SEEGER HOMES INC. - SALES OFFICE

SITE DEVELOPMENT PLANS  
LOT 3, APPALOOSA HIGHWAY 24 SUBDIVISION

SALES OFFICE - SPECIAL USE  
DEVELOPMENT PLAN

SHEET NO:  
C-01  
DATE:  
05/25/18  
PAGE NO:  
1 OF 1

SHEET NO:
C-01

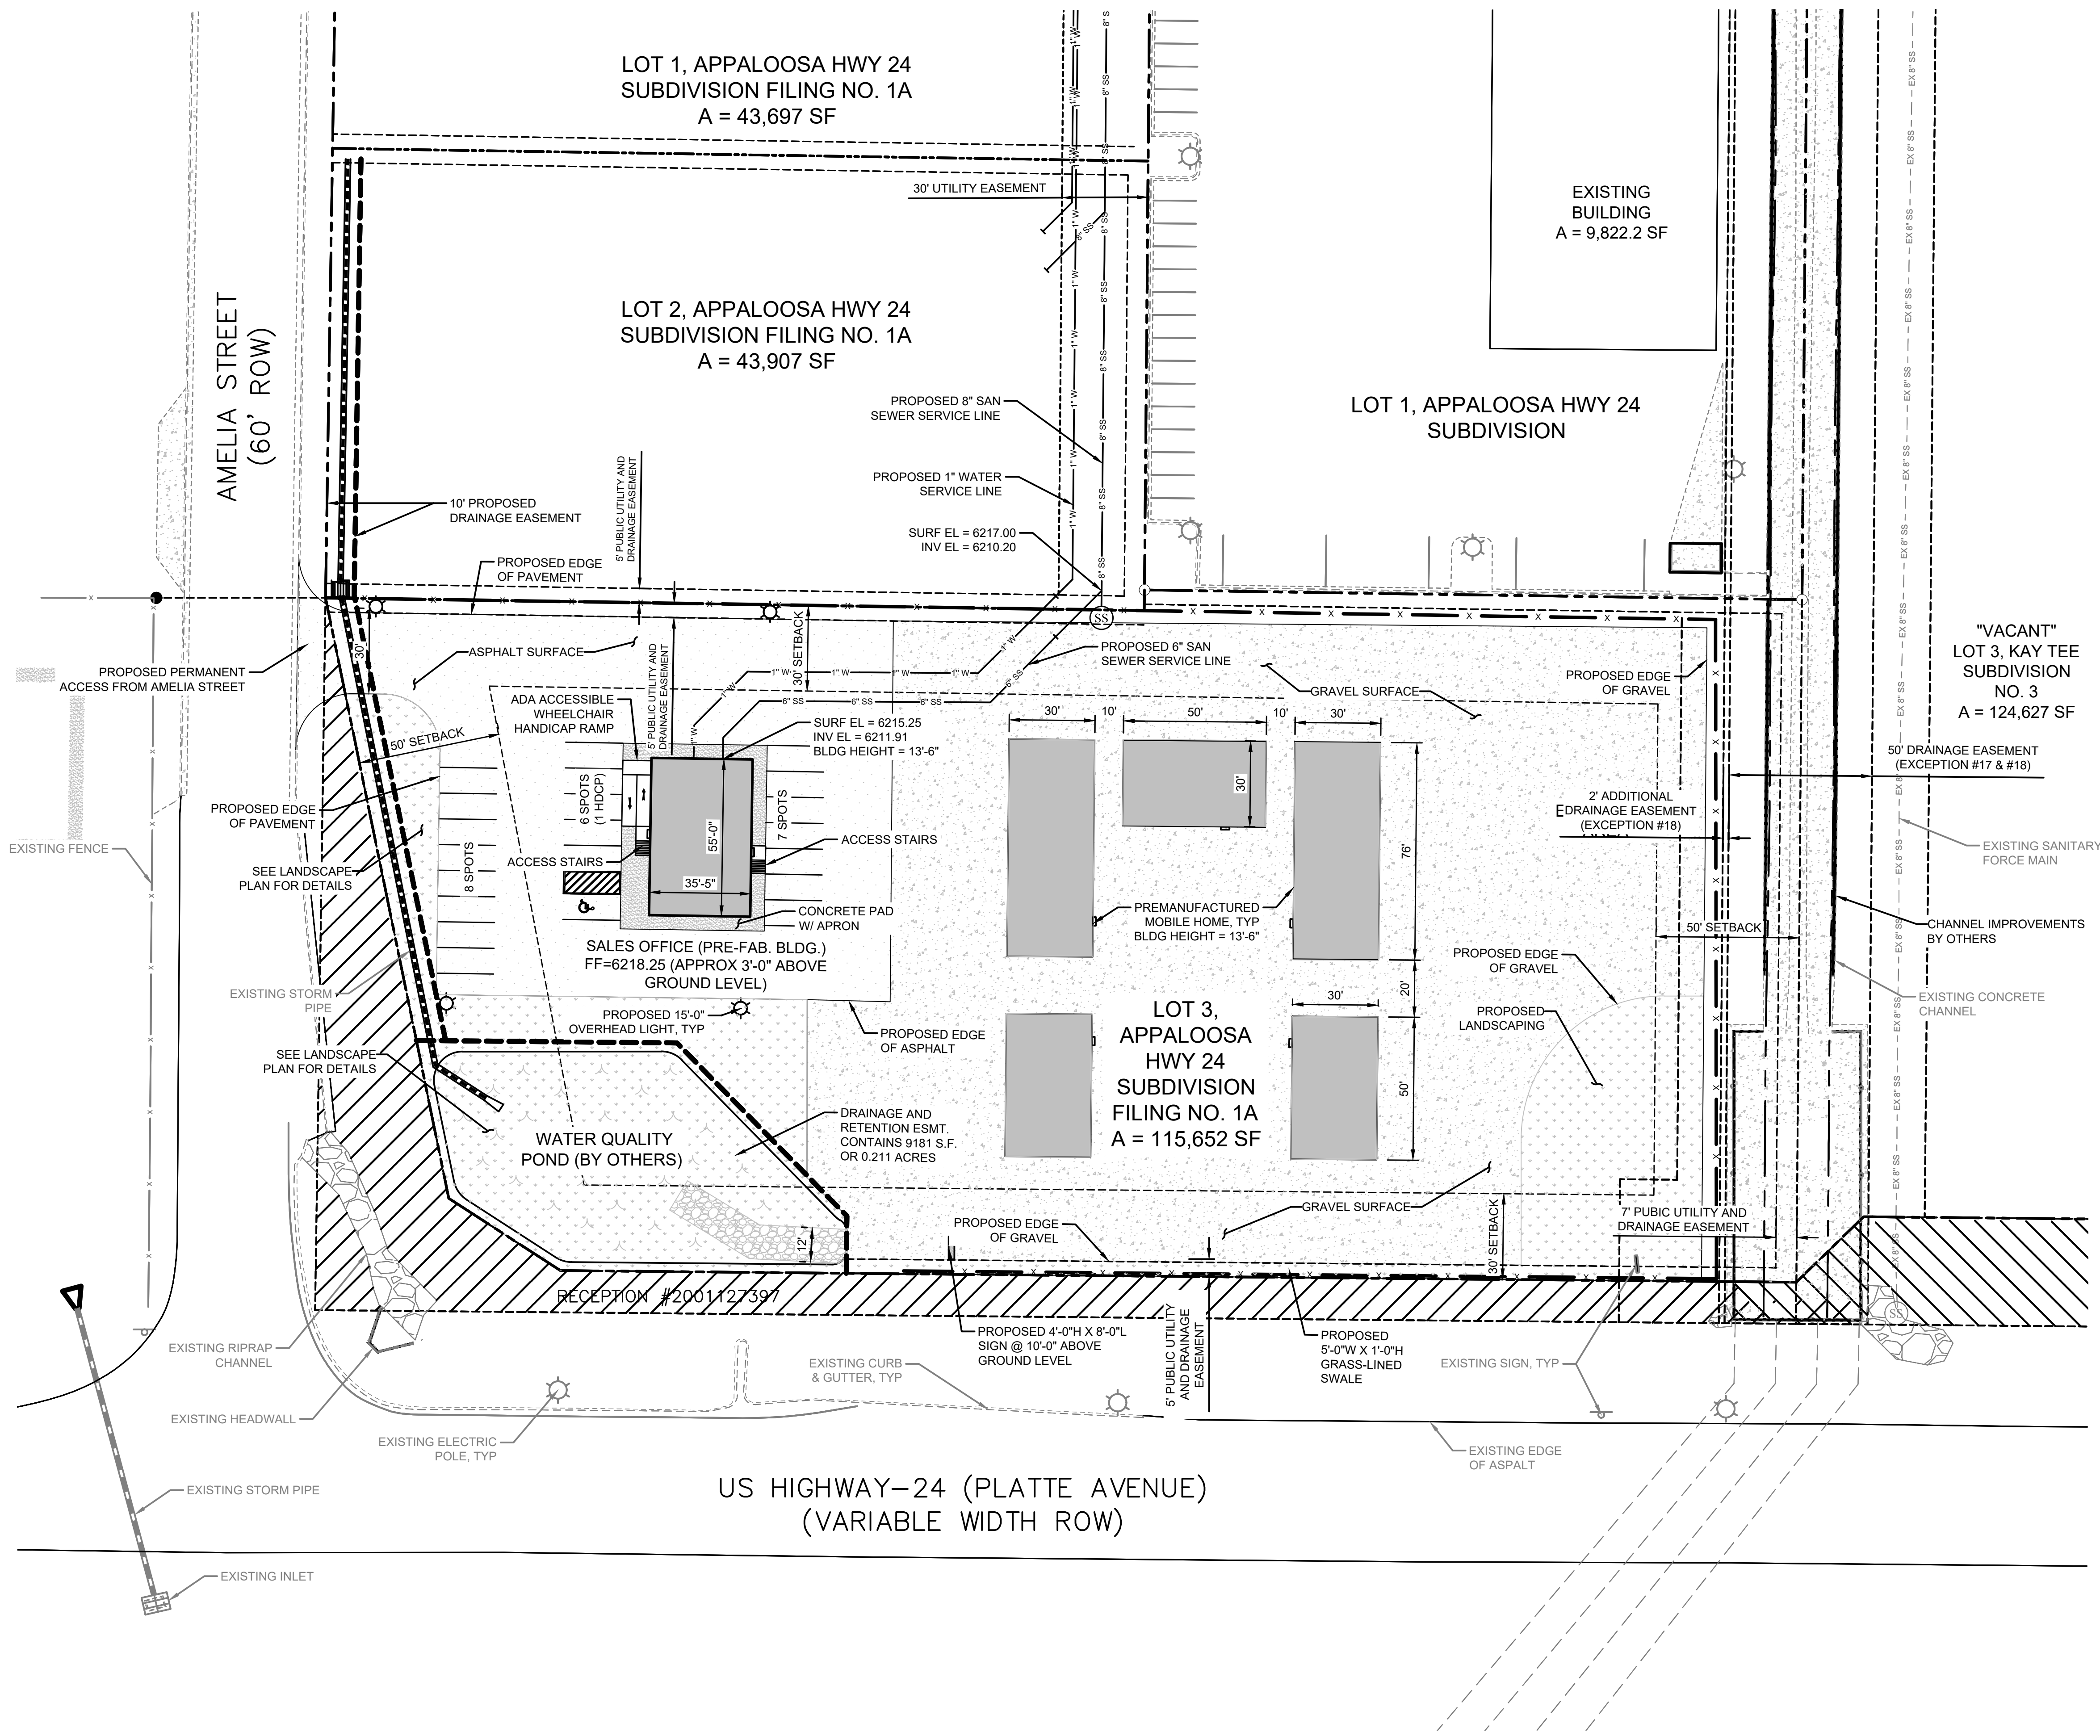
Driveway access permit will be required.  
Application form is available at the PCD front desk

Provide legend for various line types used on the plan

Is this a temporary or permanent site plan?

Add "Channel improvements by others"

Does this all have to be gravel?  
Can you provide more vegetative coverage?

Be sure this sign is outside of the public ROW.

Add PCD File No. PPR1831

Provide dimension of proposed drainage  
easement

Identify all adjacent property owners by owner name or platted subdivision name.

4 spots for office.

9 spots for Homes area..

1 HC spot required.
